D2016/140915

SSD 7917 – Warehouse/Distribution and Light Industrial Facility – Lot 3 Horsley Drive Business Park

**Appendix 1 – Erosion & Sediment Control Plan**

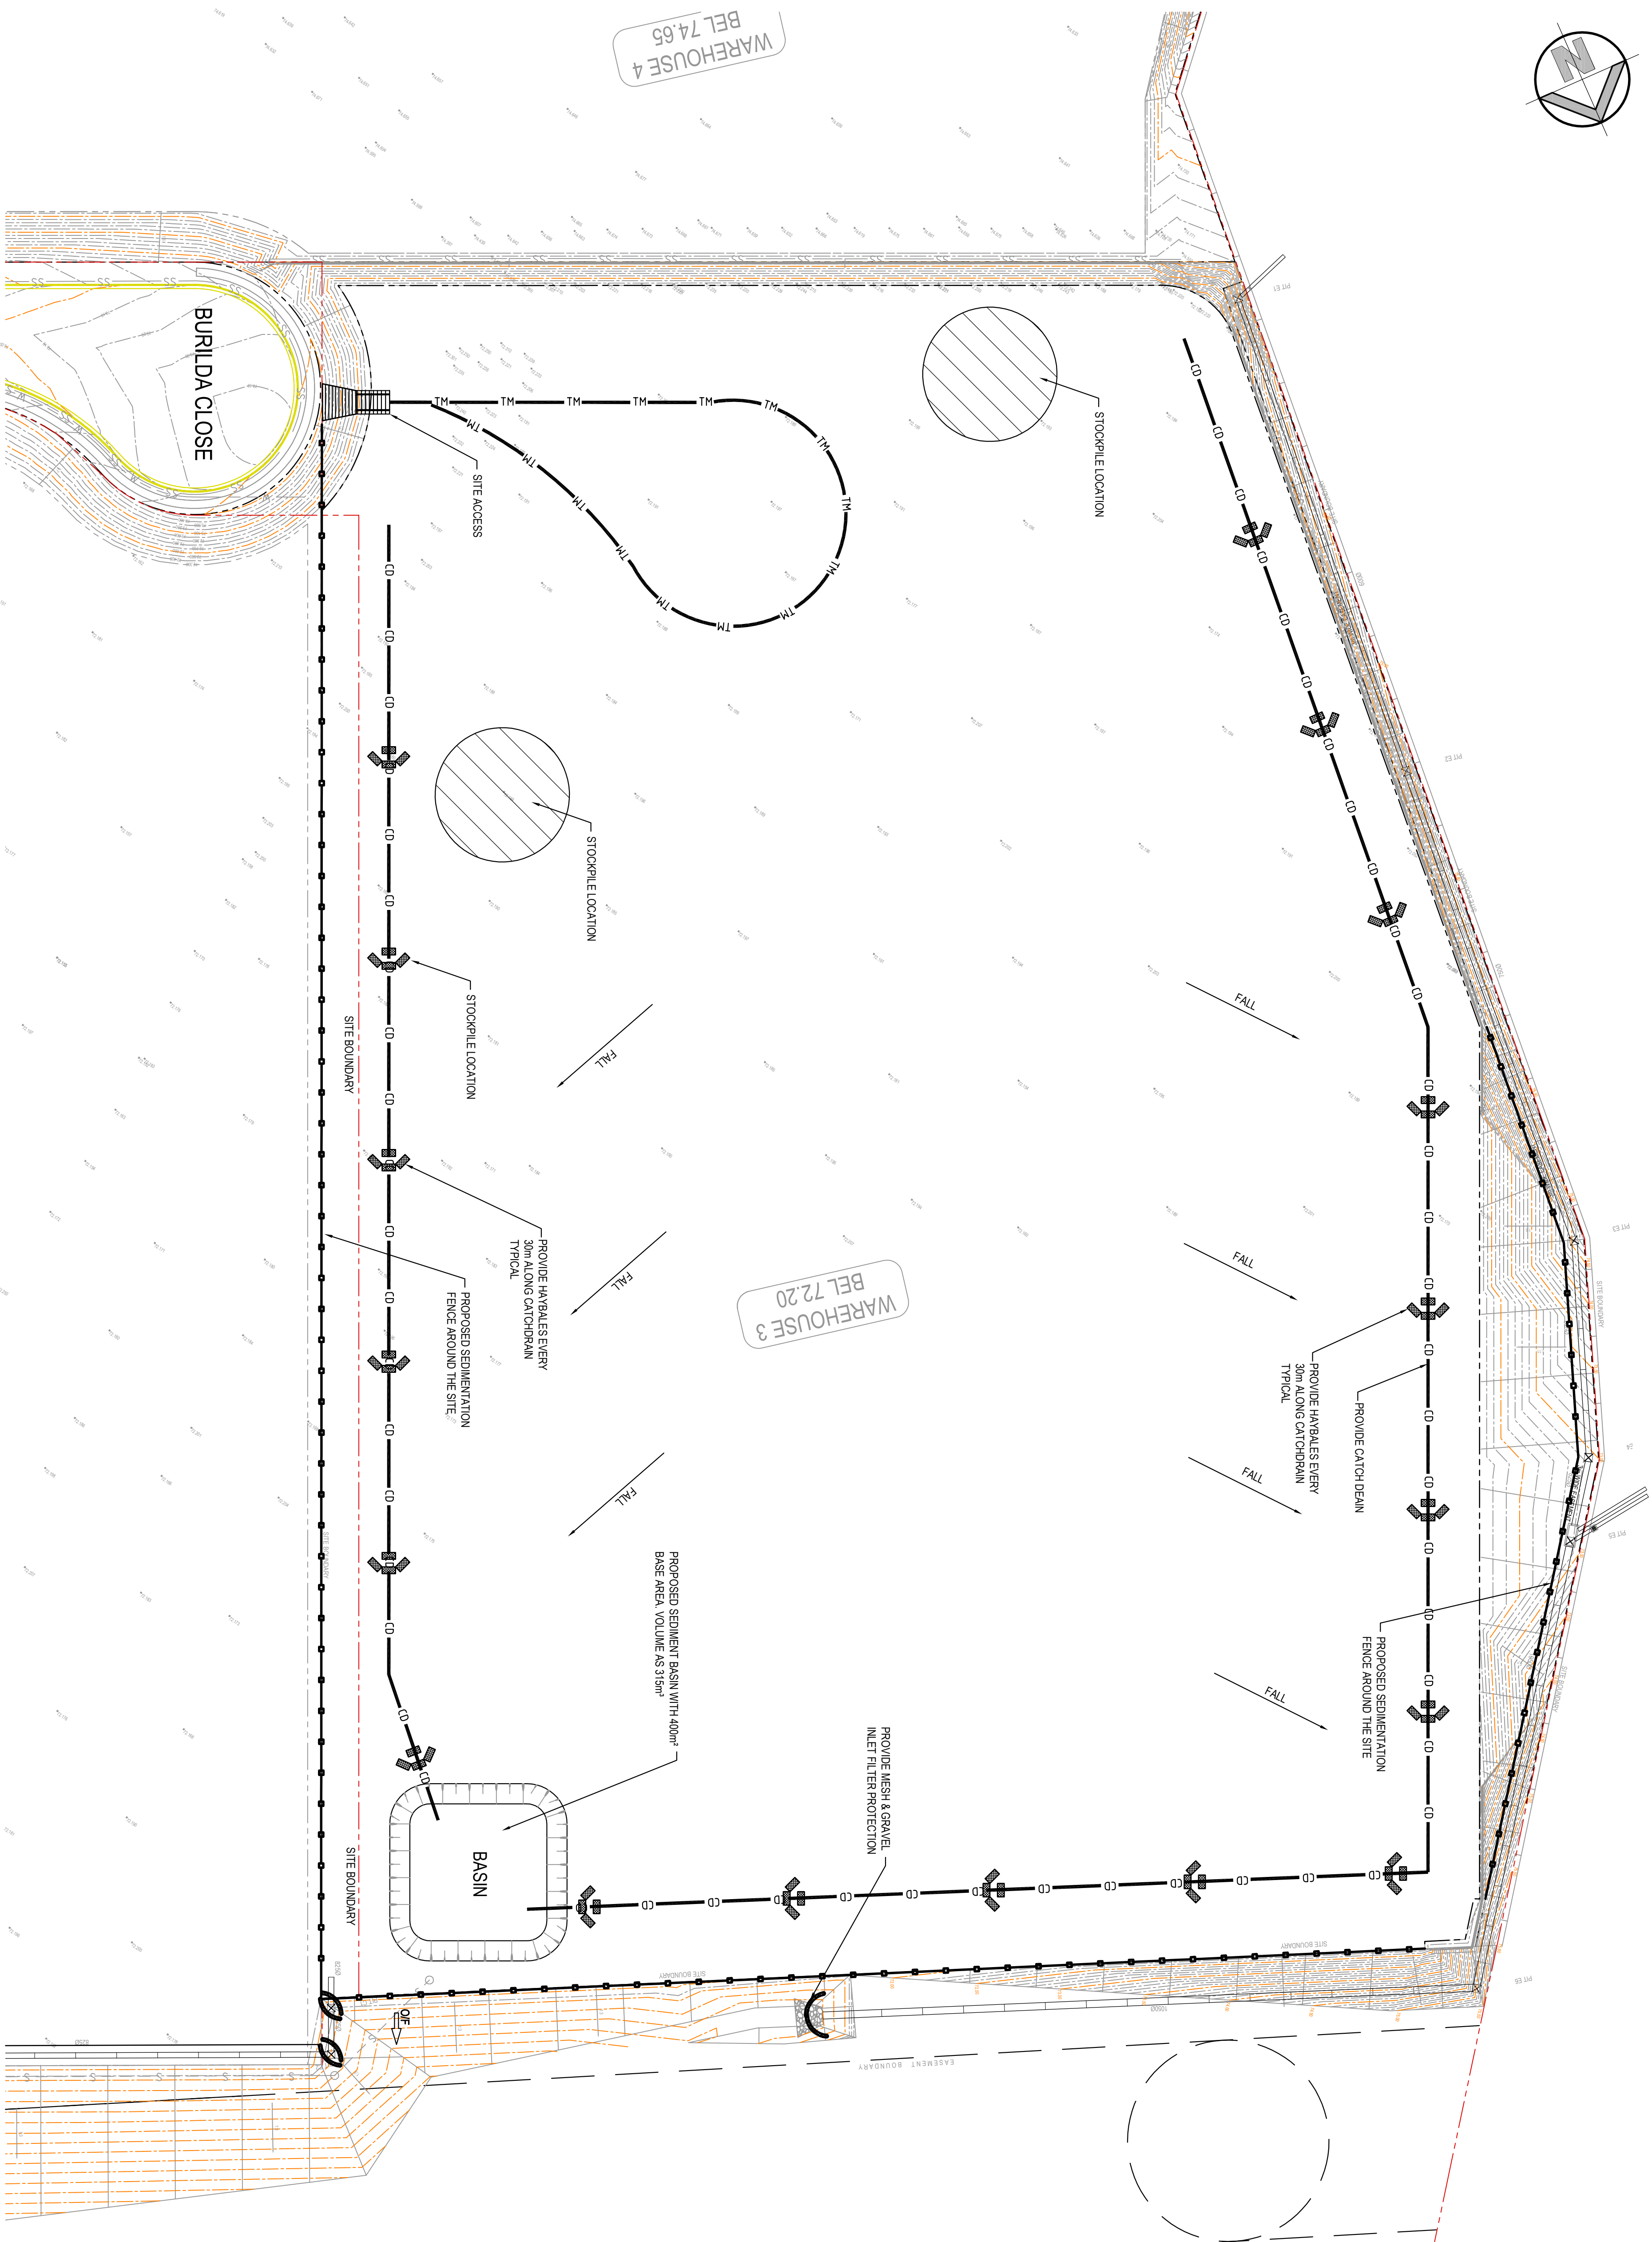
The land around the inlet pit on WaterNSW land located to the south of the site (Pit E1) has been scoured by runoff from the cycleway, demonstrating the pit is not properly engineered and/or located to capture this runoff. It is noted that sandstone rubble and geofabric have been

put in place in an attempt to prevent further erosion. This is not an acceptable solution, and the issue must be rectified immediately to the satisfaction of WaterNSW.

It was also noted that the soil in the corridor supporting the edge of the cycleway approximately 50 metres North of inlet pit E1 was falling away due to earthworks that had been carried out as part of the development. WaterNSW requires the proponent to rectify this issue immediately and install measures to prevent further deterioration of the land within the corridor.

- It was noted that part of the finished surface of the site between the ends of the retaining walls along the boundary with the Upper Canal corridor sits higher than the land within the corridor. This is leading to stormwater entering the corridor from the site, carrying soil and sediment due to the un stabilised surface. This was particularly evident around the northern inlet pit E5.

The proponent must immediately install sediment control measures such as sediment fencing on their land to arrest the ingress of sediment into the Upper Canal corridor, as well as re-shape or treat the development site to prevent stormwater from entering the corridor from the site.

- WaterNSW notes a large amount of stockpiled fill in the centre of the site. No further spreading of fill should be carried out near the boundary fence, exacerbating the issue identified above of stormwater entering the Upper Canal corridor from the development site. To this effect it is noted the retaining wall is proposed on the plans (Dwg SP4-WSPT-DA-003 Issue A; 5.10.2016) to run the entire length of the boundary, however on site the wall is constructed only at the northern and southern extents. Clarification is required as to whether the retaining wall will be continued for the entire length as per the plans.
